Application No: LU/55/22/L

Site Address: The Flintstone Centre East Street Littlehampton BN17 6AW

Description of works: Listed building consent for the installation of 3000mm high welded mesh fencing and associated single leaf gate along a section of the northern boundary line and along the rear elevation, Ornamental fencing and associated gates to be installed, located adjacent to the existing southern side entrance to the building, as well as the installation of 3000mm high welded mesh fence encapsulating the existing boiler room to the rear of the building, demolition of existing side secondary entrance including existing ramped access and associated fittings. Repairs to the section of wall affected by the removal of the entrance.

Thank you for your internet representation made on 8th March 2022 which has been recorded as an objection with the comments as follows:

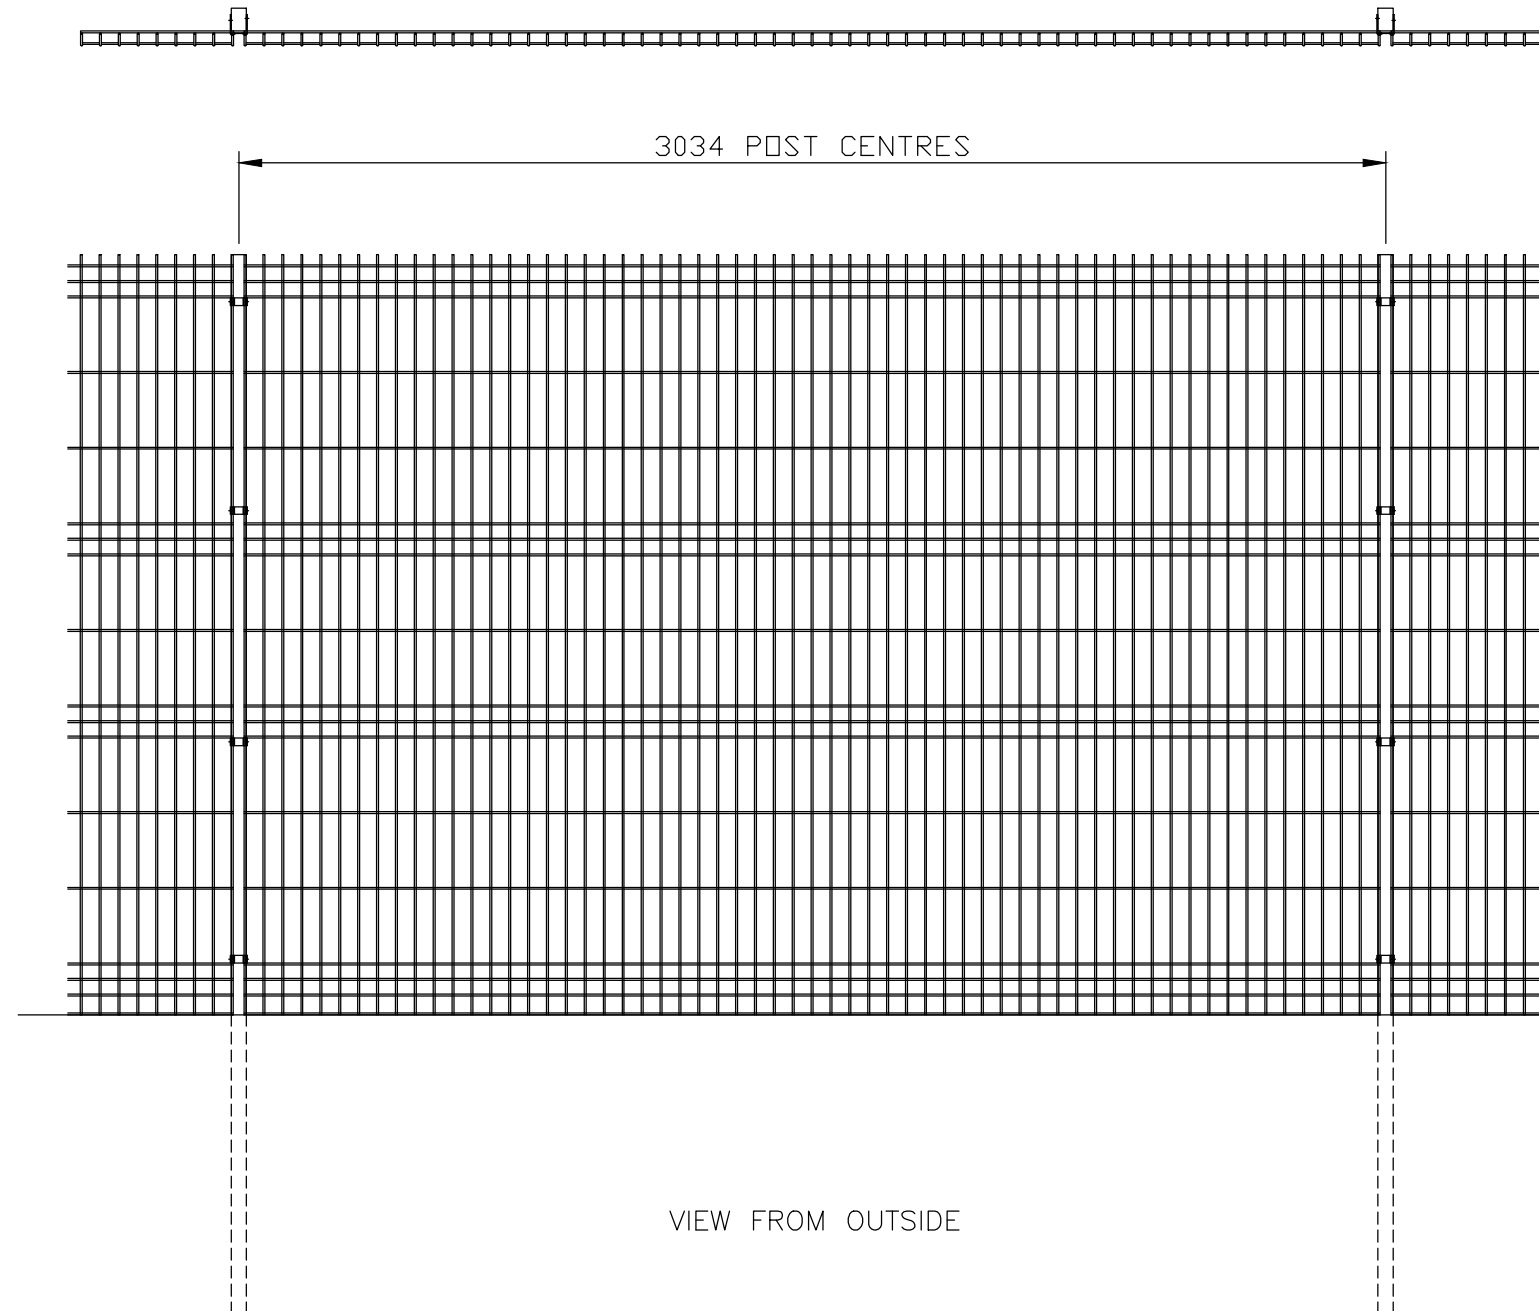
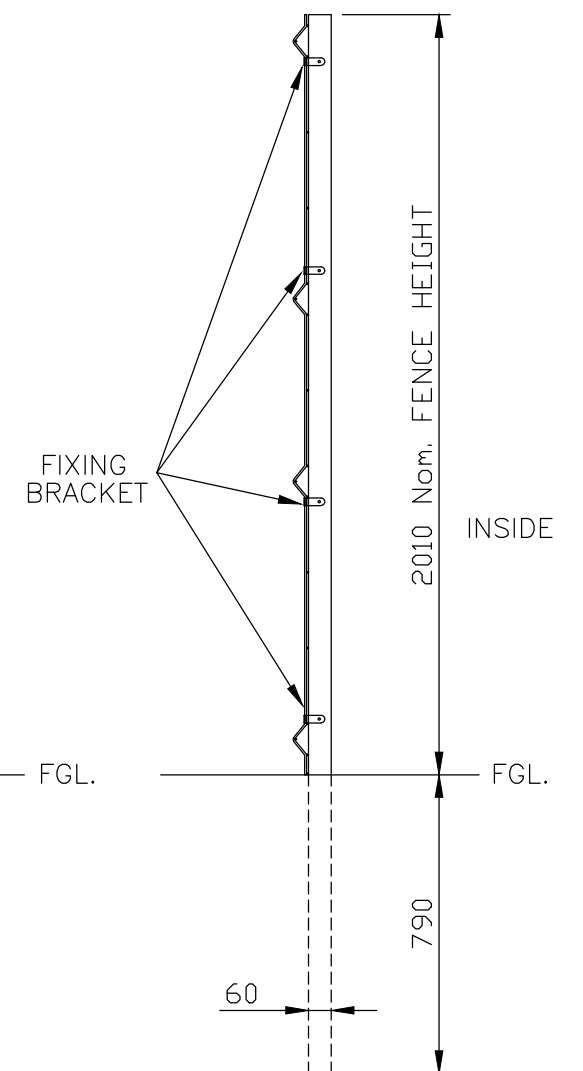
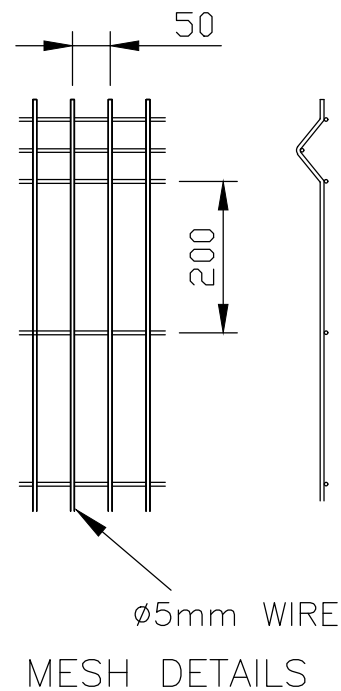
The proposed fence is welcomed as a measure to stop pupils from the school climbing over the wall to and from our development, The Old Dairy Farm, which sits behind the Flintstone Centre. However, the proposed Euroguard weld mesh fence is ugly and inappropriate, especially considering that this is a conservation area and that tight planning restrictions requiring an ornamental/heritage style gate and fencing were applied to the Old Dairy Farm development just to the rear.

The proposed Euroguard weld mesh fence is not in any way in keeping with the conservation area and would be erected within 5m of the heritage design and materials used for the gate and fence to the Old Dairy Farm.

This weld mesh fencing would be visually incongruous to the residents of The Old Dairy Farm. It would be erected within 10m of the front facade of numbers 1-5 The Old Dairy Farm, protruding above the existing flint wall, and also along the garden wall of number 8. The Euroguard weld mesh fencing looks more appropriate for use surrounding a prison or similar. Previous discussions with the Council stressed that the planning submission would include heritage/conservation style fencing to the rear, and not an ugly and inappropriate weld mesh fence.
